Our Ref: FP/161/08/

27th August 2008

Loft conversion
10 Thirlmere Way Felpham

DRW NO 5 SCALE 1/100
PROPOSED ELEVATIONS

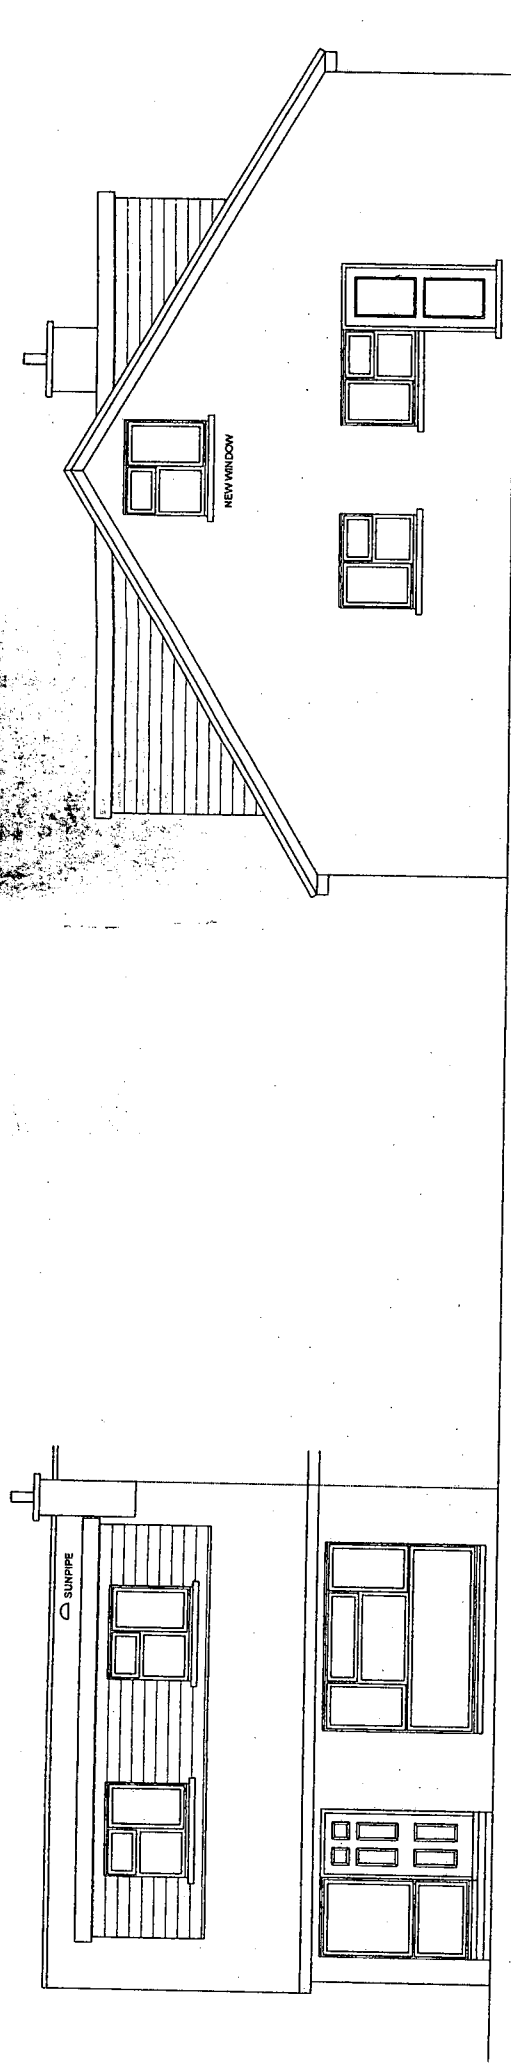
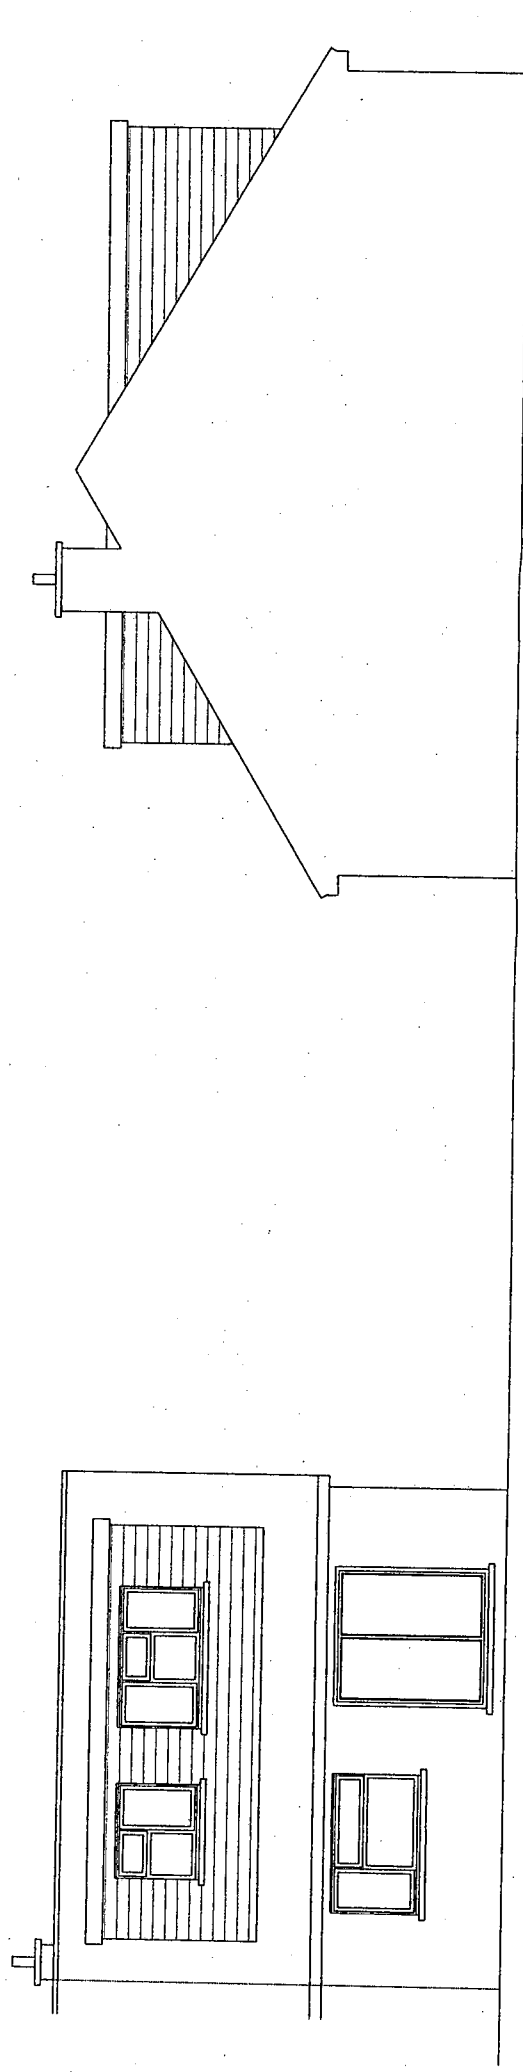
No objection with the proviso that the new bathroom window should have obscure glass.
